From: Fiona Fitzgerald
Sent: 05 March 2025 16:11
To: Planning.Responses
Cc: Jessica Riches
Subject: F/14/24/RES, F/15/24/RES, F/16/24/RES
Attachments: FORD.docx

Environmental Health **objects** to F/14/24/RES on the basis of both **noise** and **odour**.

Environmental Health objects to these three applications F/14/24/RES, F/15/24/RES and F/16/24/RES both individually and cumulatively. The applicant has failed to cumulatively assess noise sources within each individual application. However, given that this is a phased development, it is imperative that all phases of the development are also assessed cumulatively, meaning that the noise assessments must cover all phases, not just the specific areas referred to in these 3 applications. If this is not done, the applicant runs the very real risk of future phases being unable to be built due to intractable noise issues.

F/14/24/RES

Status:	Drawn by:	Checked by:
For Planning	GP	TF
Project Number:	Scale @ A1:	Date:
180641	1:500	06/2024
Drawing Number:		Revision:
TOR-RMN-XX-DR-L-P-002		C

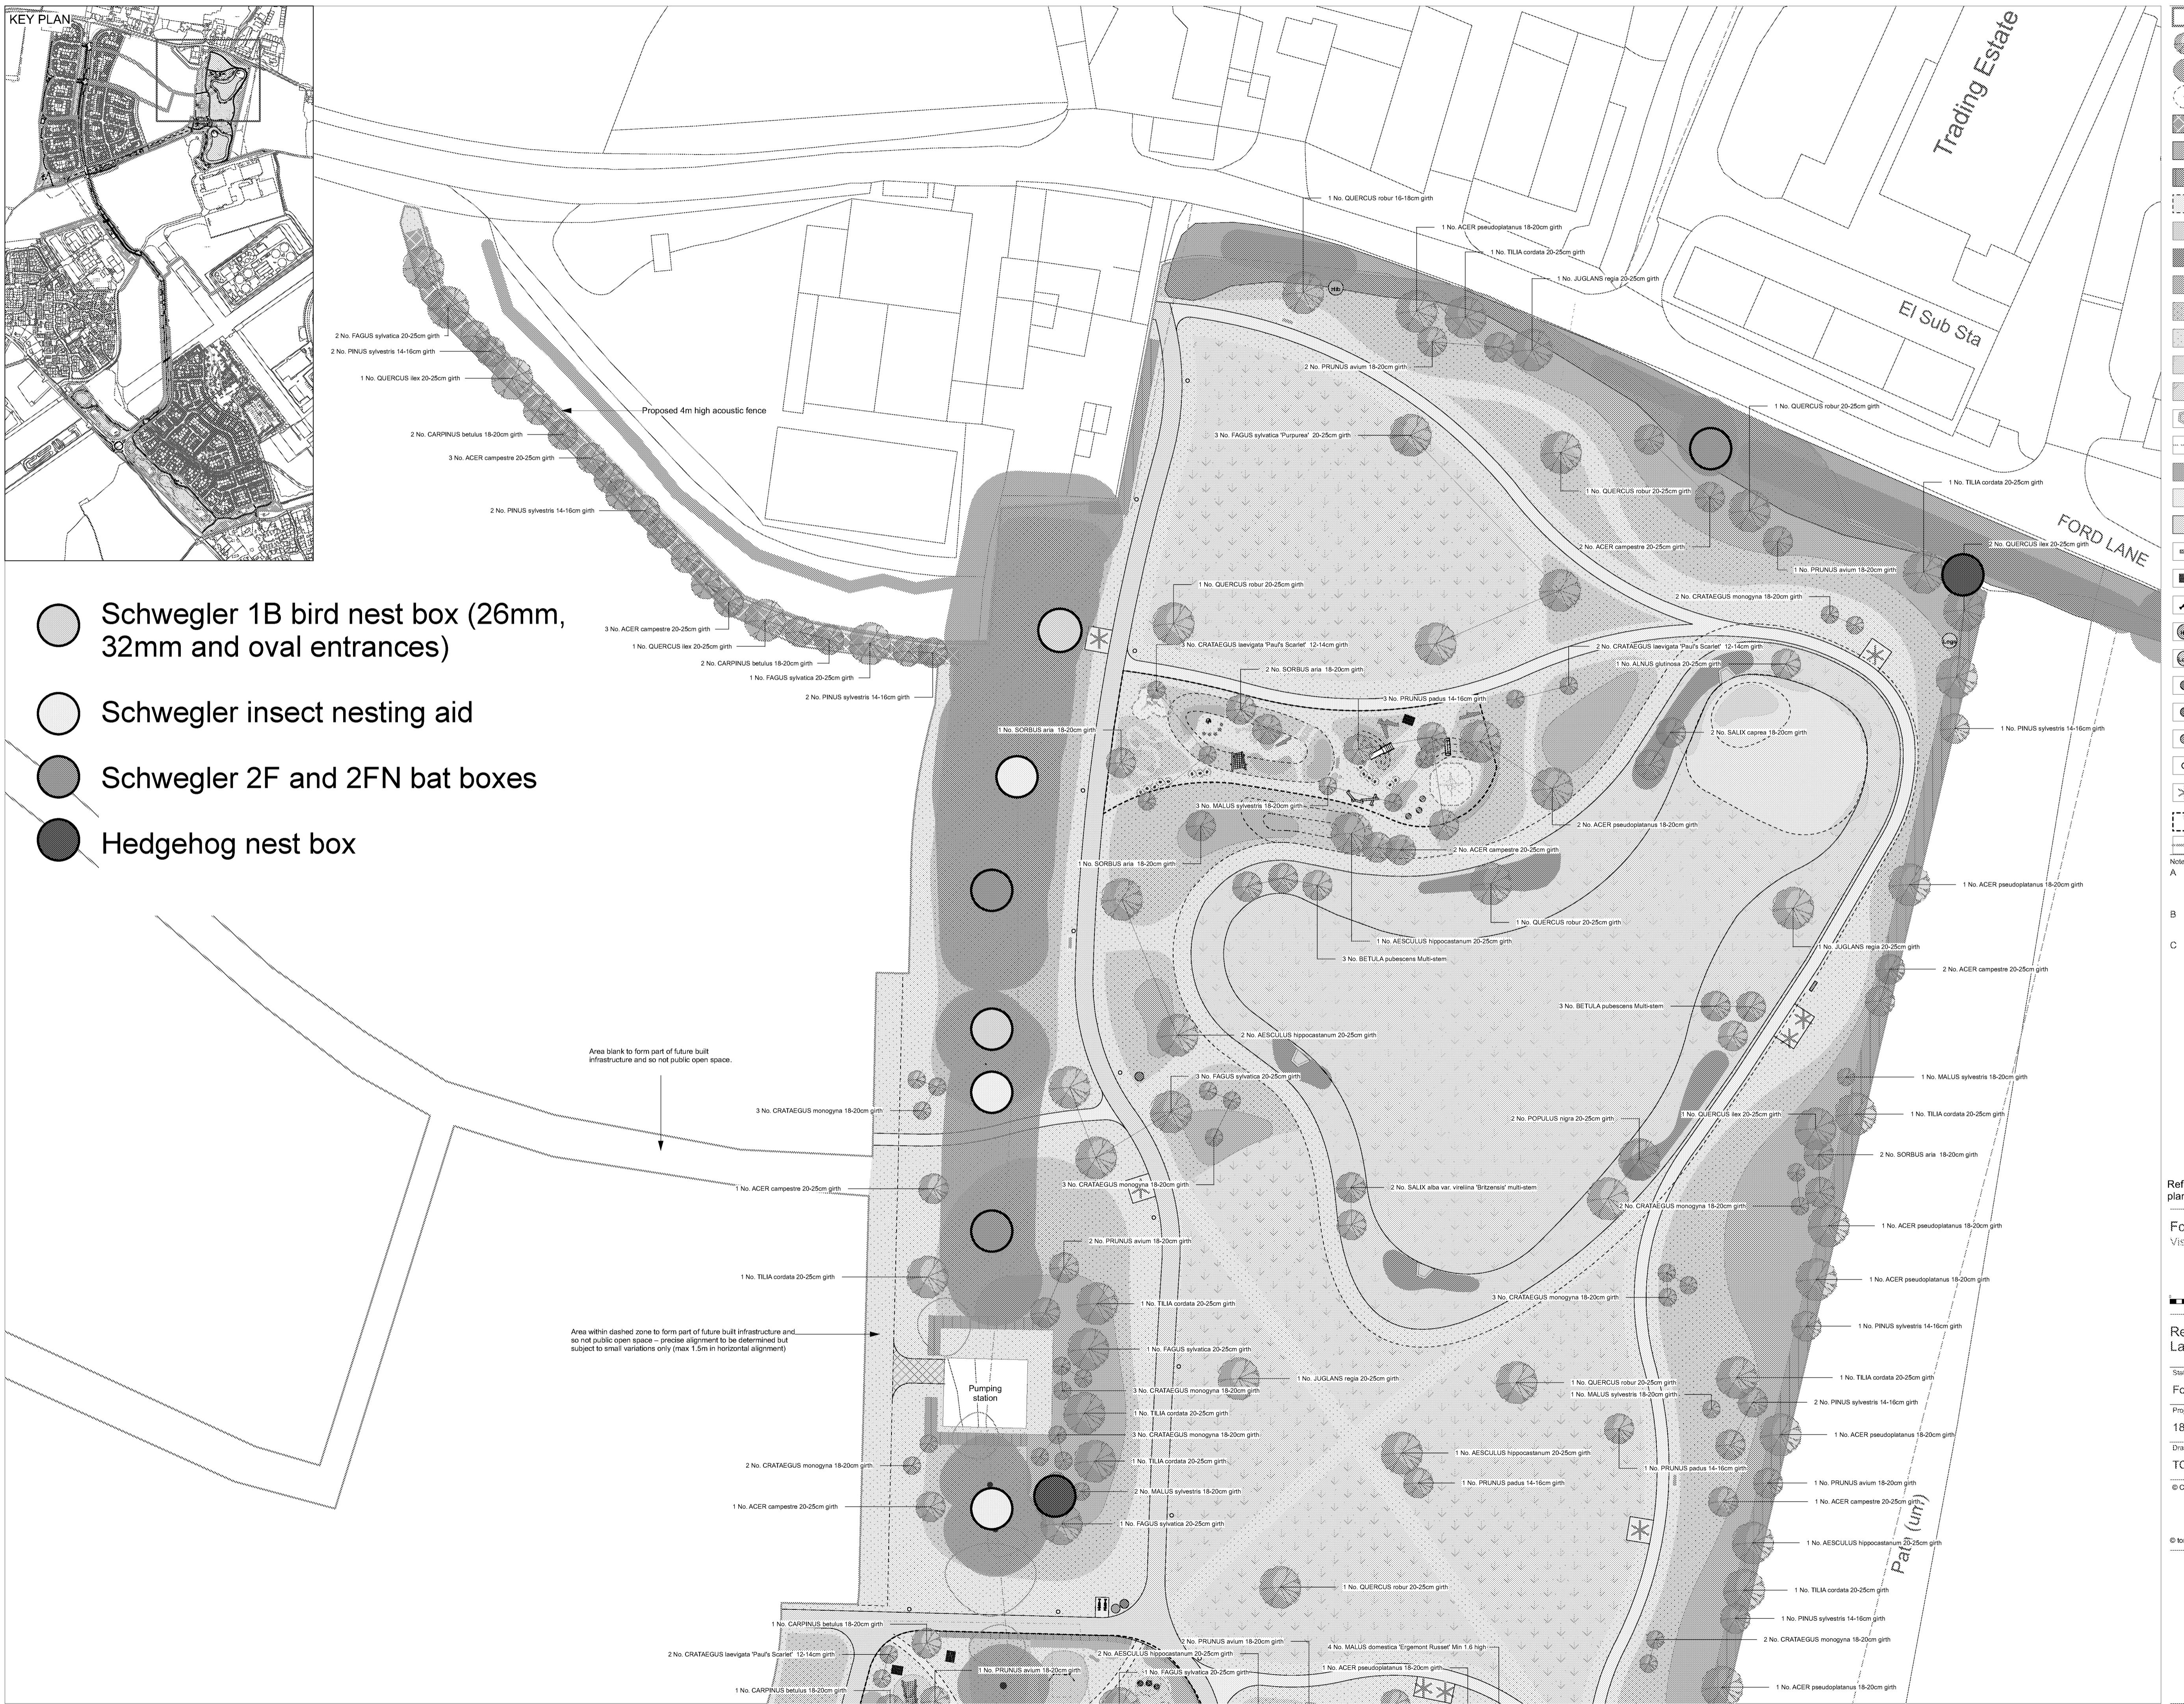
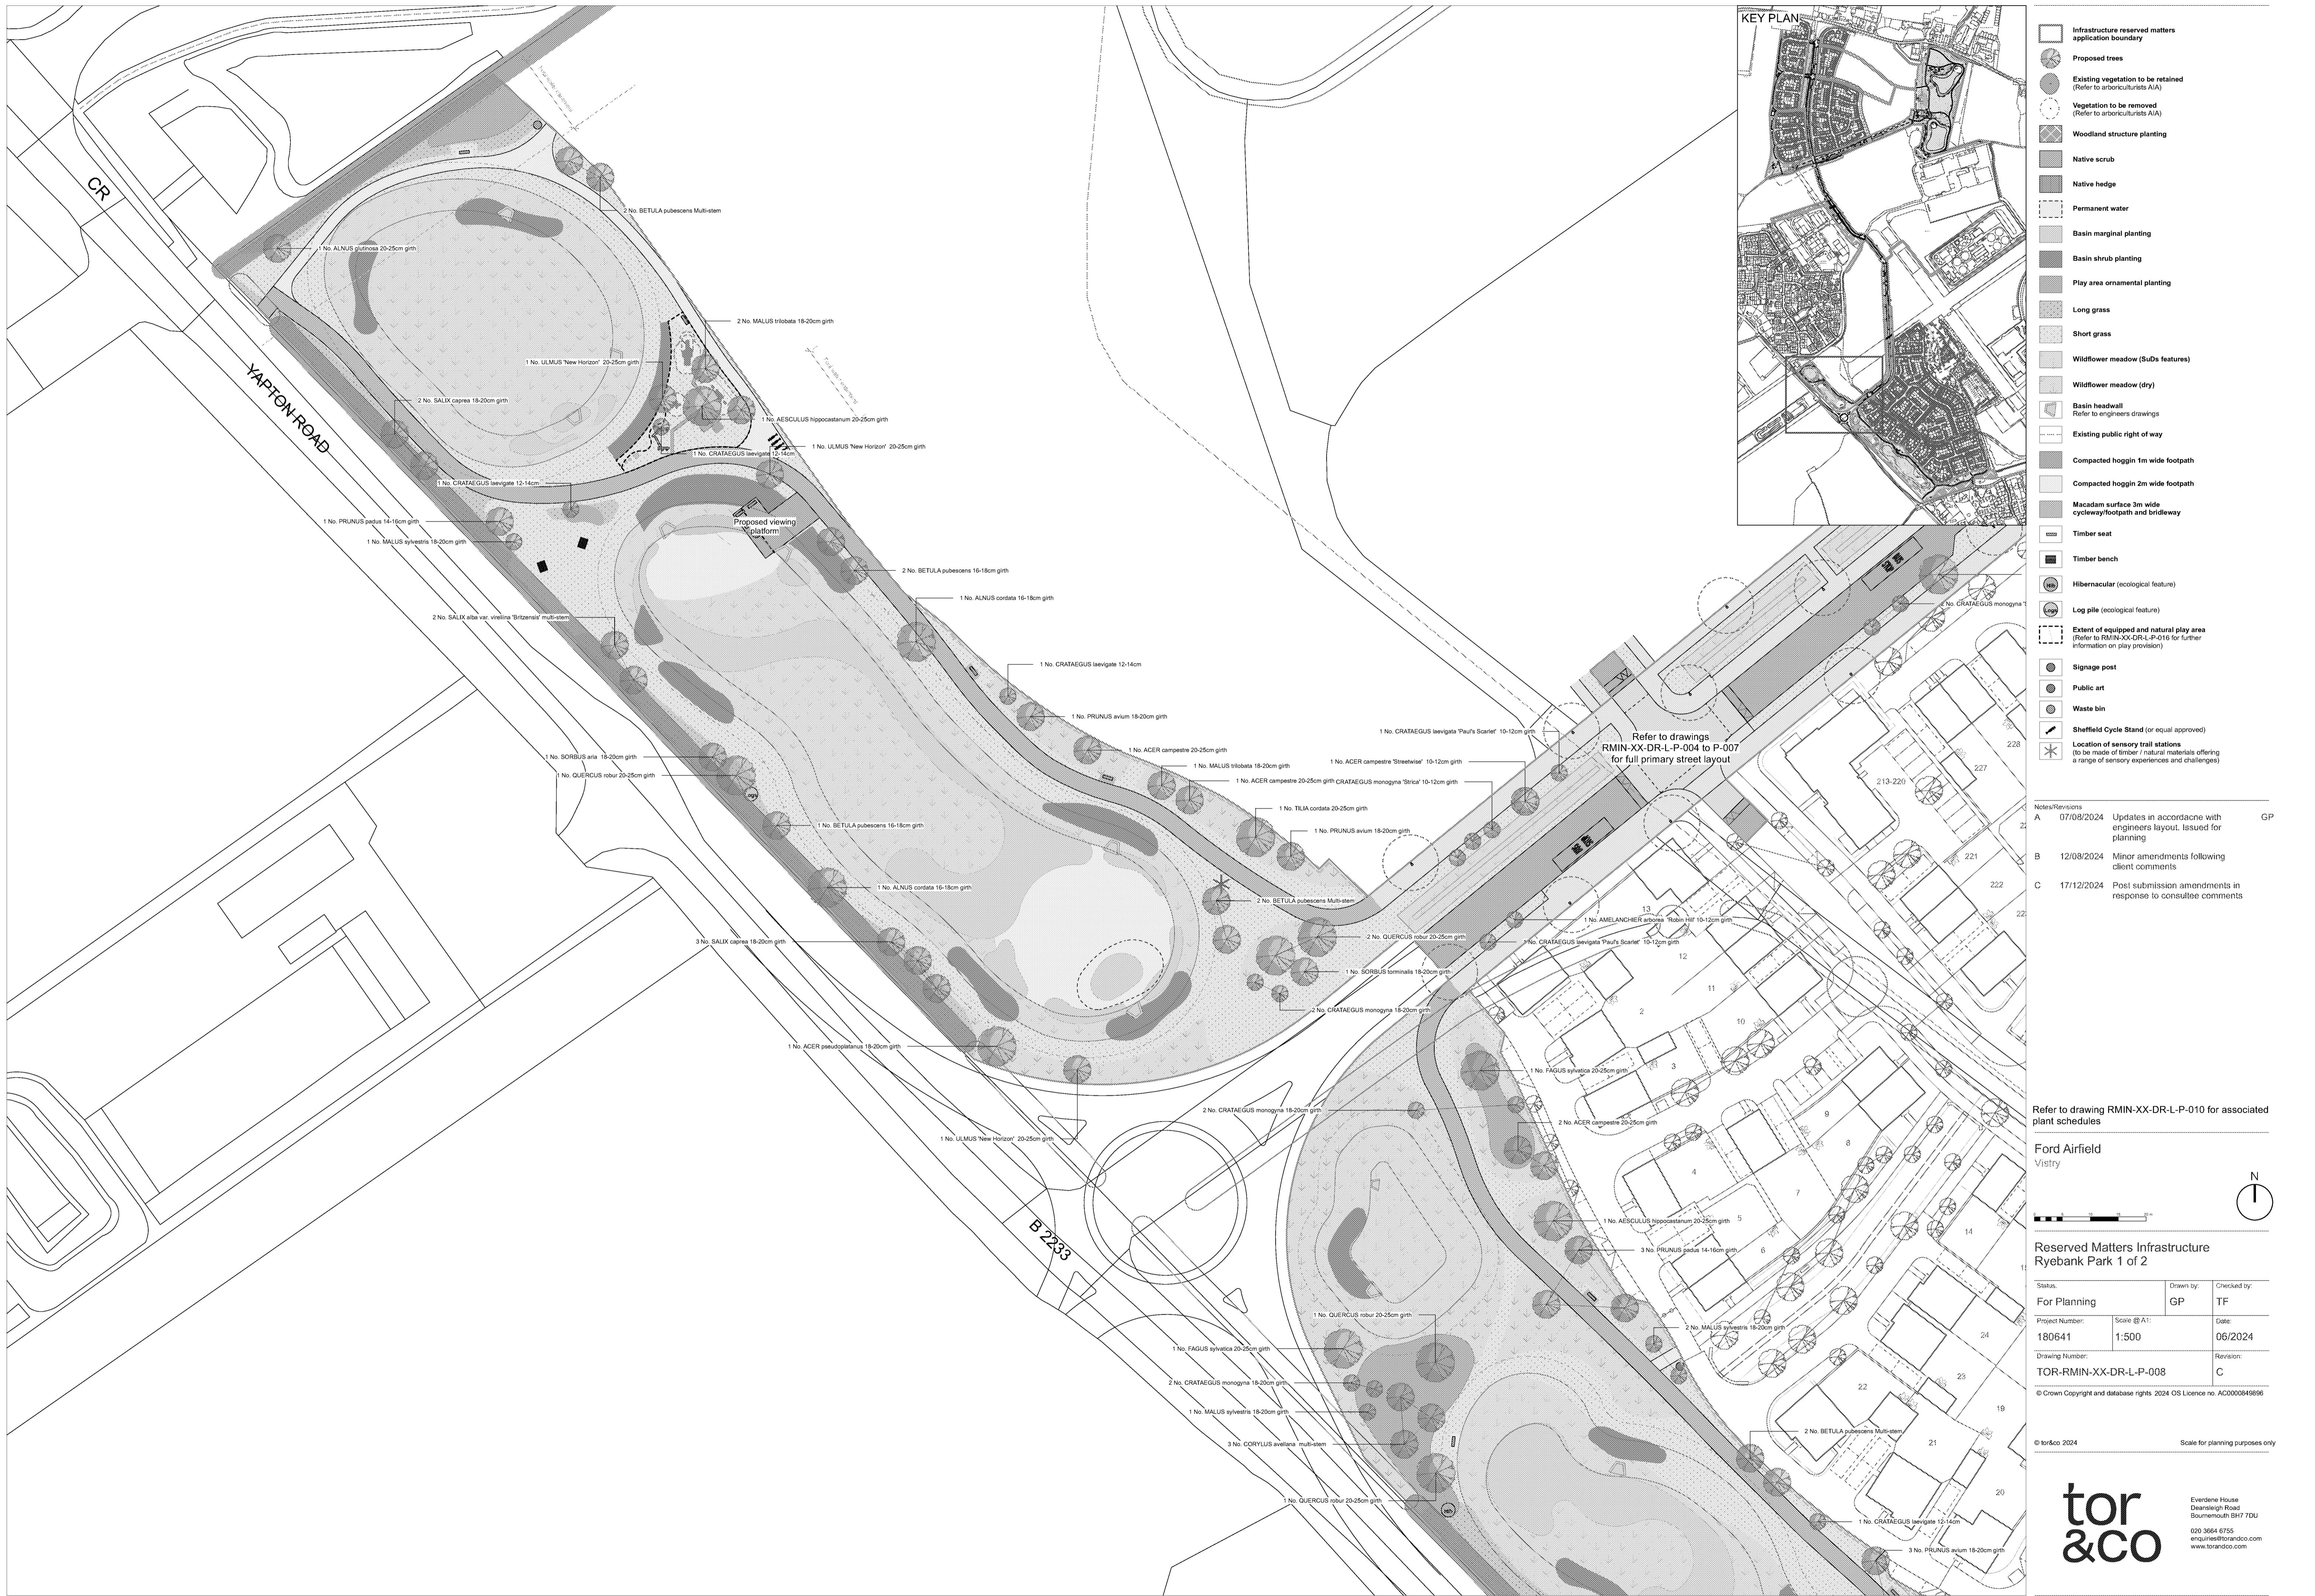
14. Landings green 1 of 2 TOR-RMIN-XX-DR-L-P-001 B shows location of 'proposed 4m high acoustic fence' but this is virtually invisible as it is covered by a red line. It is impossible to tell the extent of this fence, and no further details are provided.

15. Composite landscape master plan RM1, RM4 and RMI TOR-RMIN-XX-DR-L-P013 Rev A shows timber closeboard fence 1.8m high but does not indicate whether this is part of the noise mitigation or not.

16. Same document has 4m high acoustic fence shown in the key, and possibly located on the north-east most residential premises, but it is almost impossible to tell if this is the case.
